Application by Steeple Solar Farm Limited for an order granting development consent for the Steeple Renewables Project

**The Examining Authority's written questions and requests for information (ExQ2):
Response of Nottinghamshire County Council**

## Appendix 2: Typical PV Module Rack Detail for Ballasted Foundations

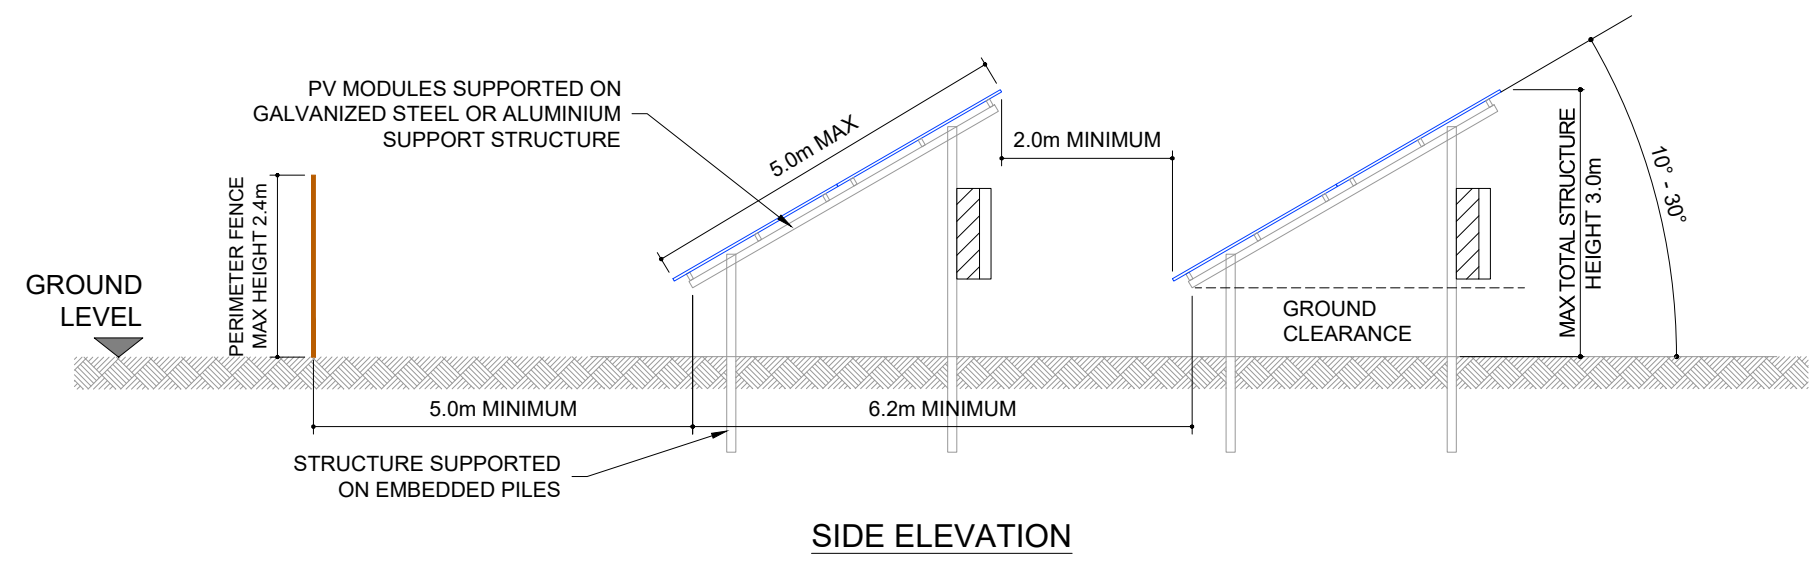
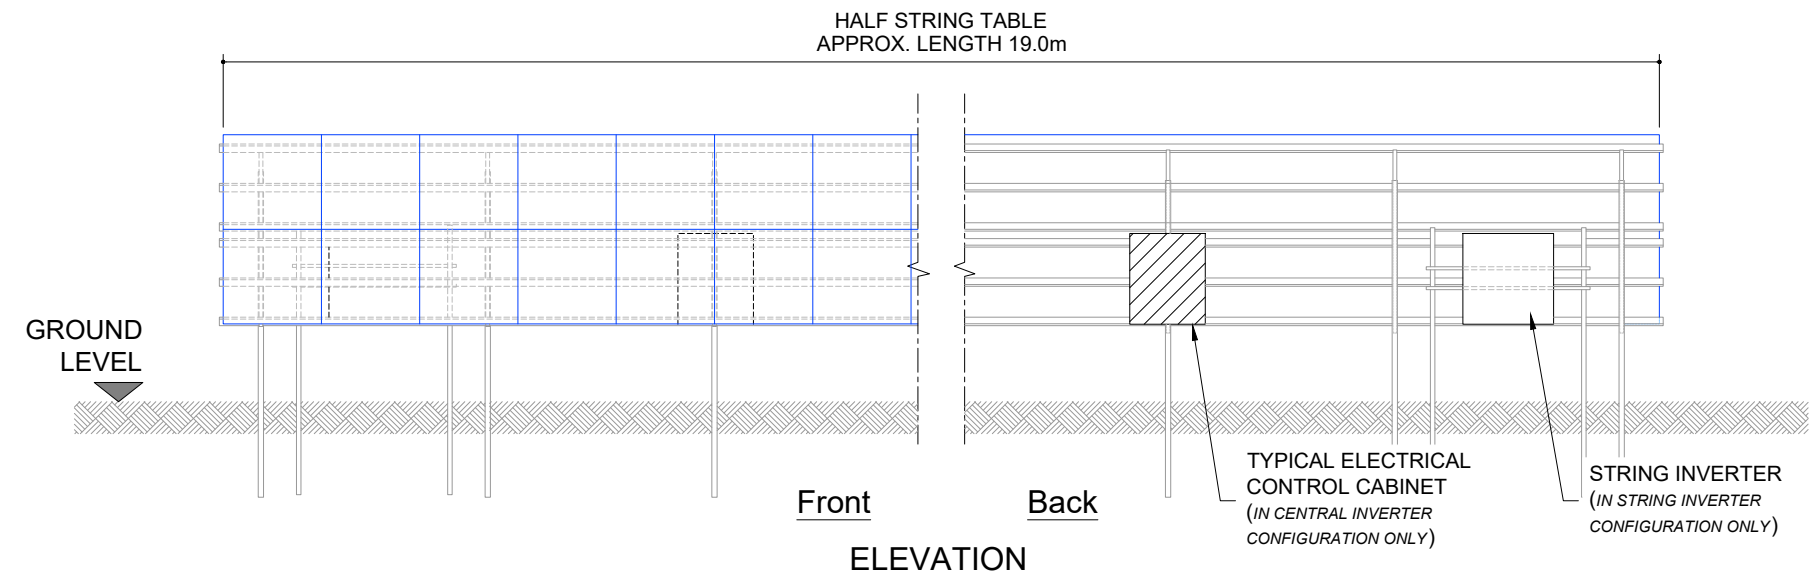
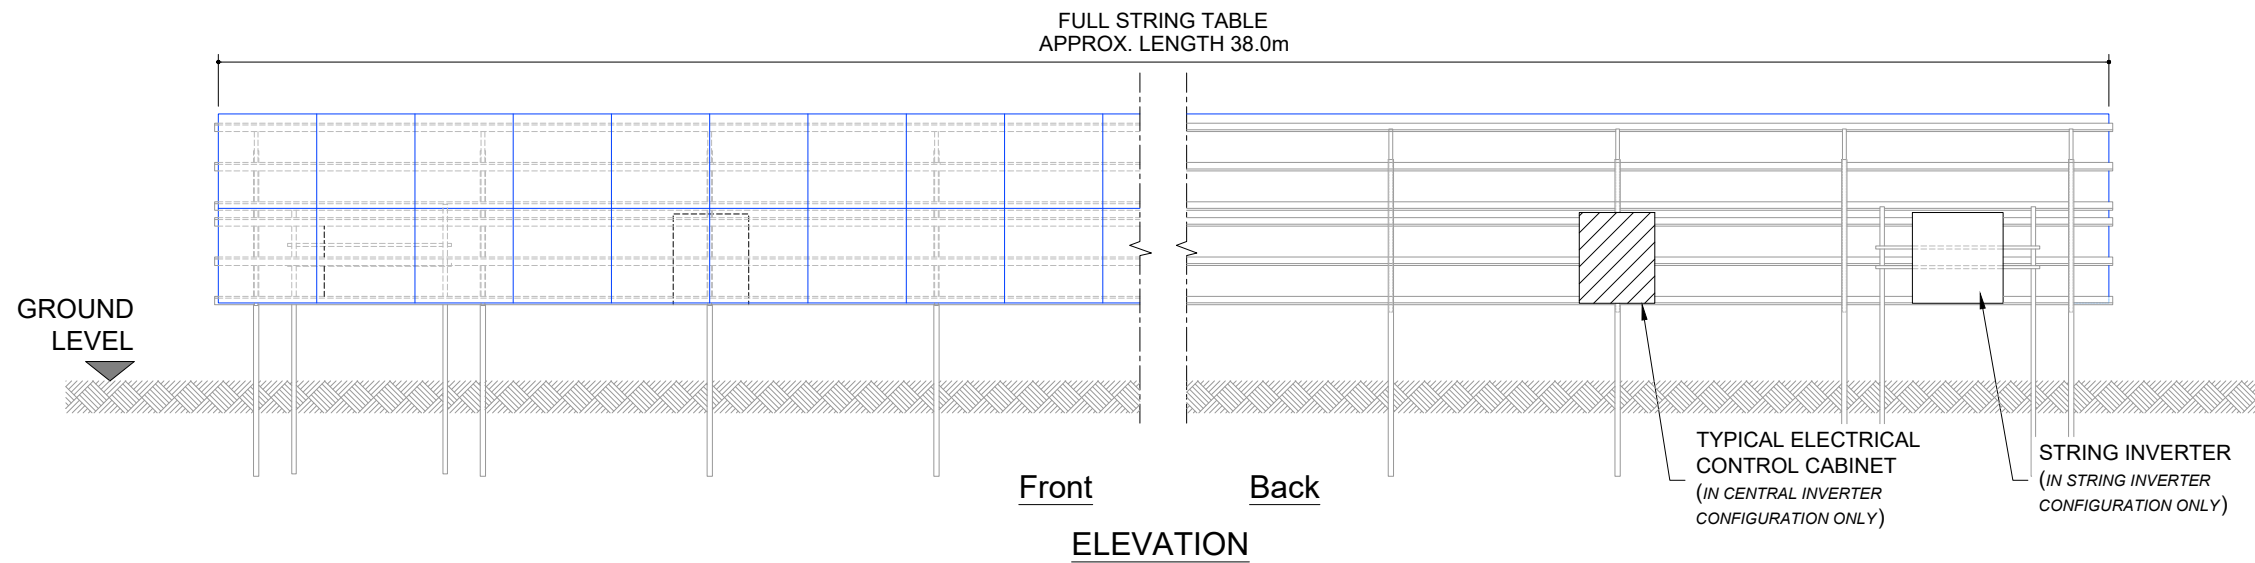
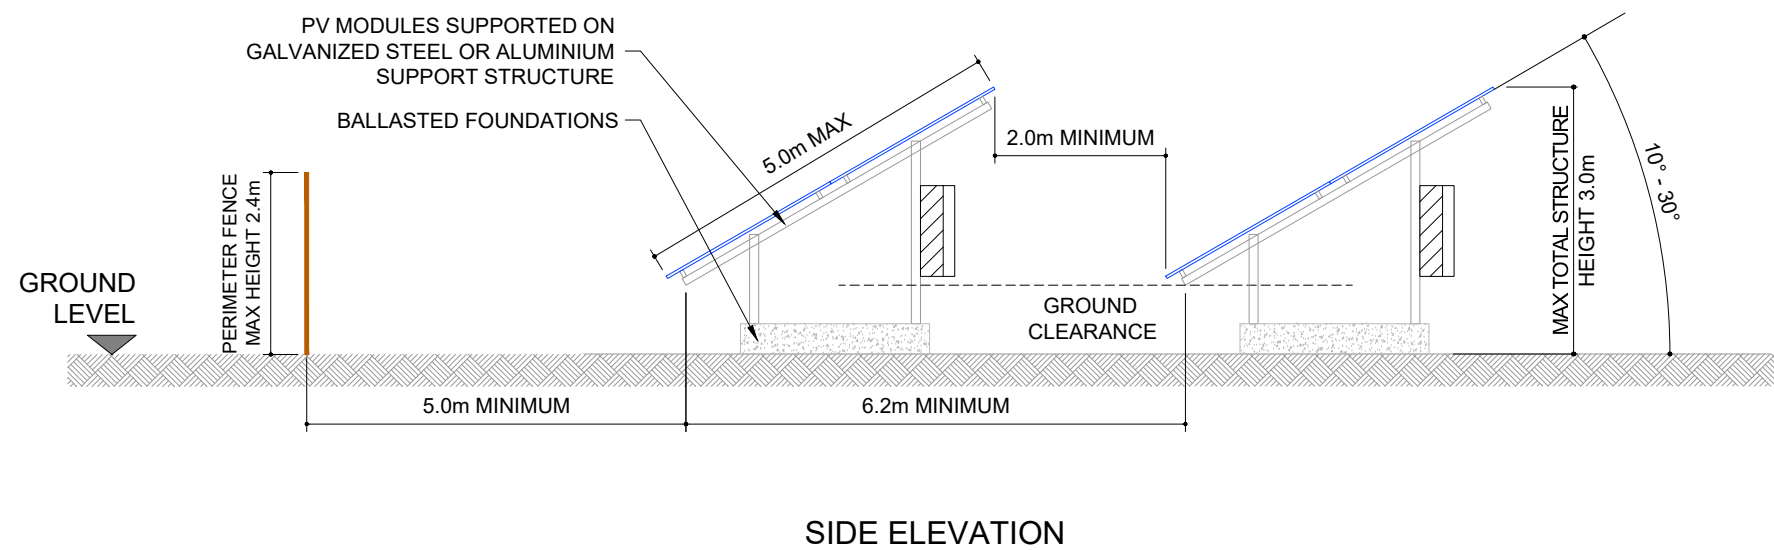
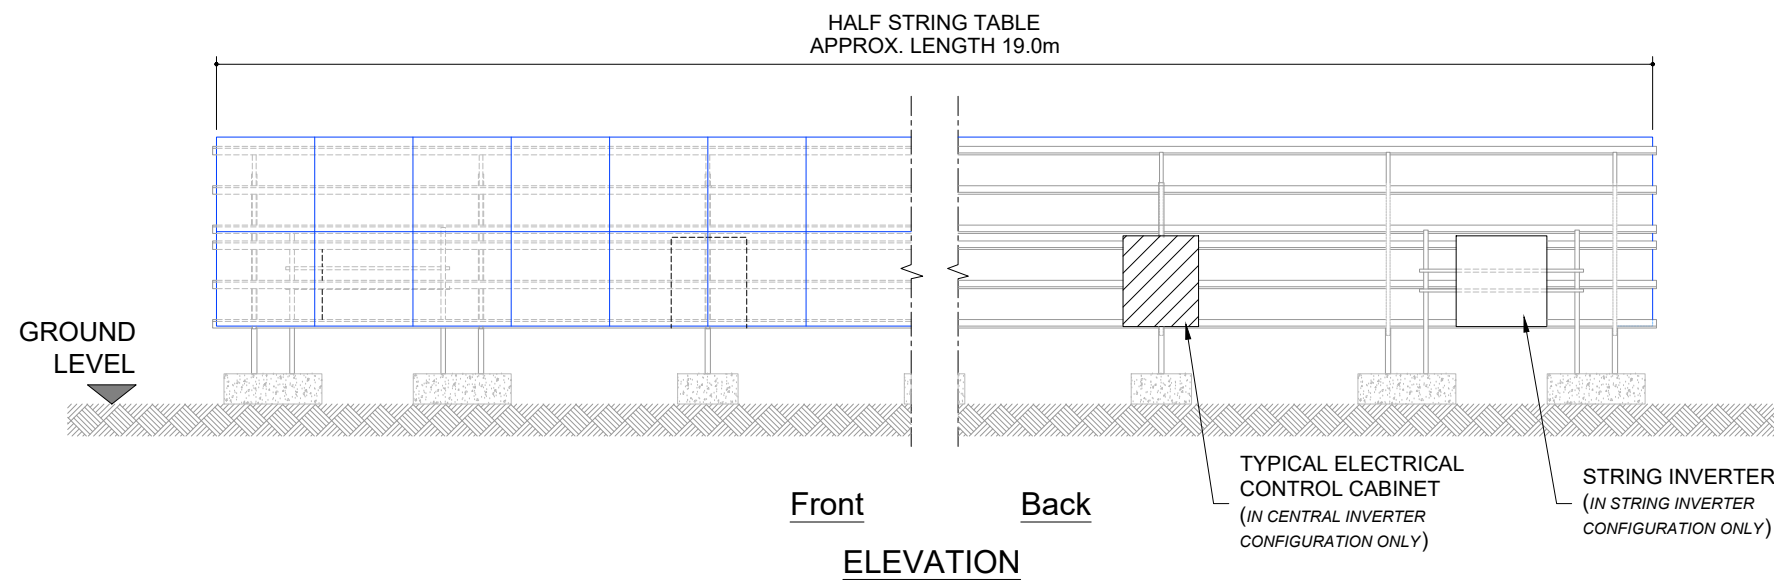
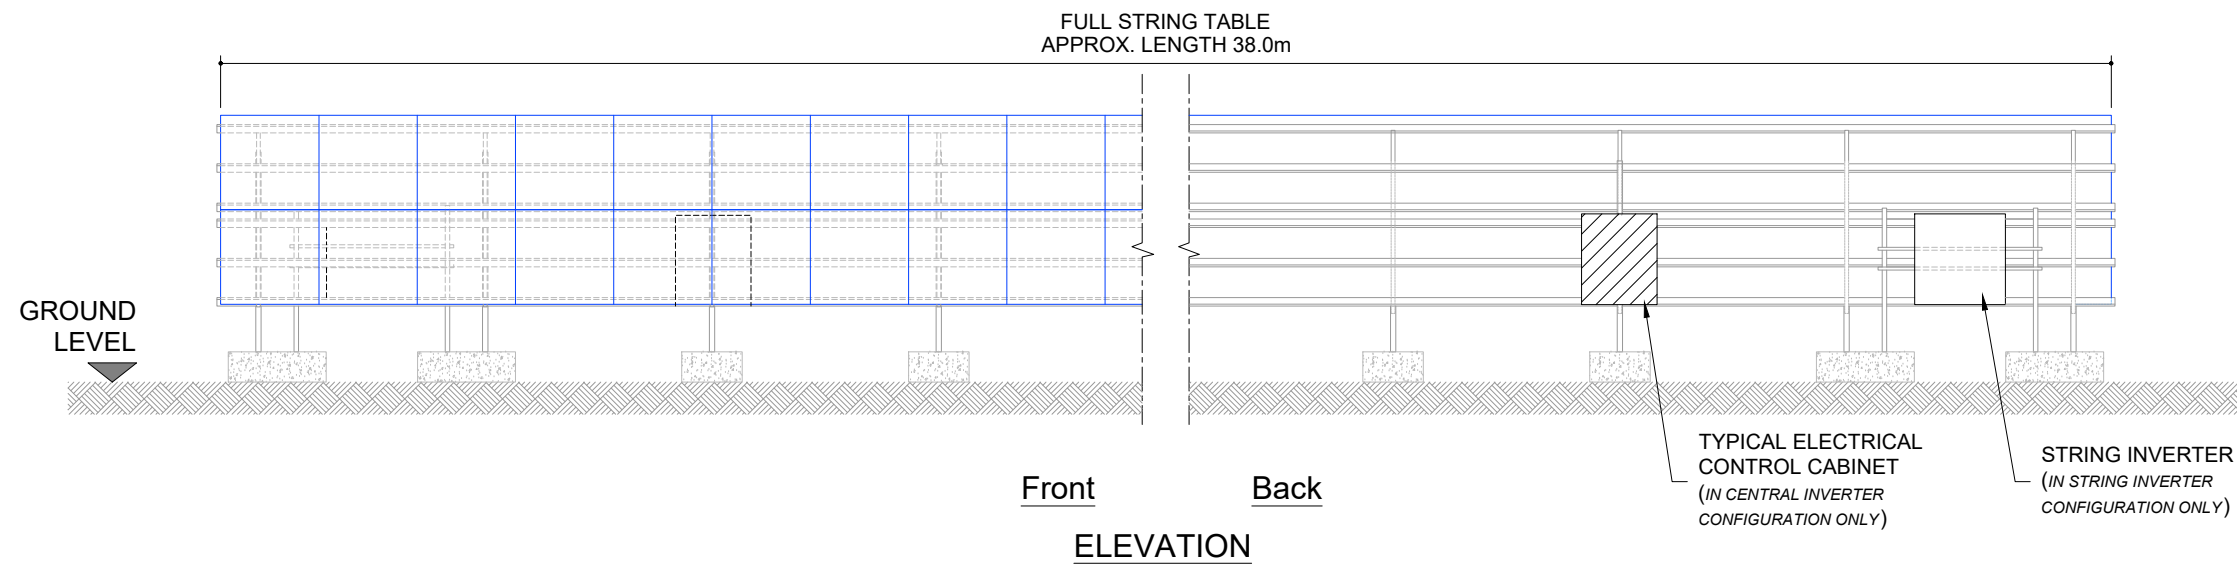
The use of ballast slab foundations as a preservation technique can be problematic. Primarily, the use as a preservation technique has not been tested sufficiently to establish its efficacy. In addition, this technique often requires ground preparation which in itself can be damaging to archaeological deposits, especially remains at a shallow depth. There are also significant concerns around ground compaction beneath the concrete slabs which will also have a negative impact on sensitive and shallow remains.

The use of concrete slabs should always be informed by trial trench evaluation so that the depth, character and sensitivity of the remains being preserved can be properly understood and an assessment on the appropriateness of this technique presented as part of the mitigation strategy. For instance, it may be appropriate where sensitive archaeological remains are present at significant depth but would not be appropriate for shallow sensitive features such as those containing human or structural remains.

Further assessment of the site-specific circumstances and details of the construction and implementation (including detail on decommissioning) would be required to assess the appropriateness of this mitigation strategy.
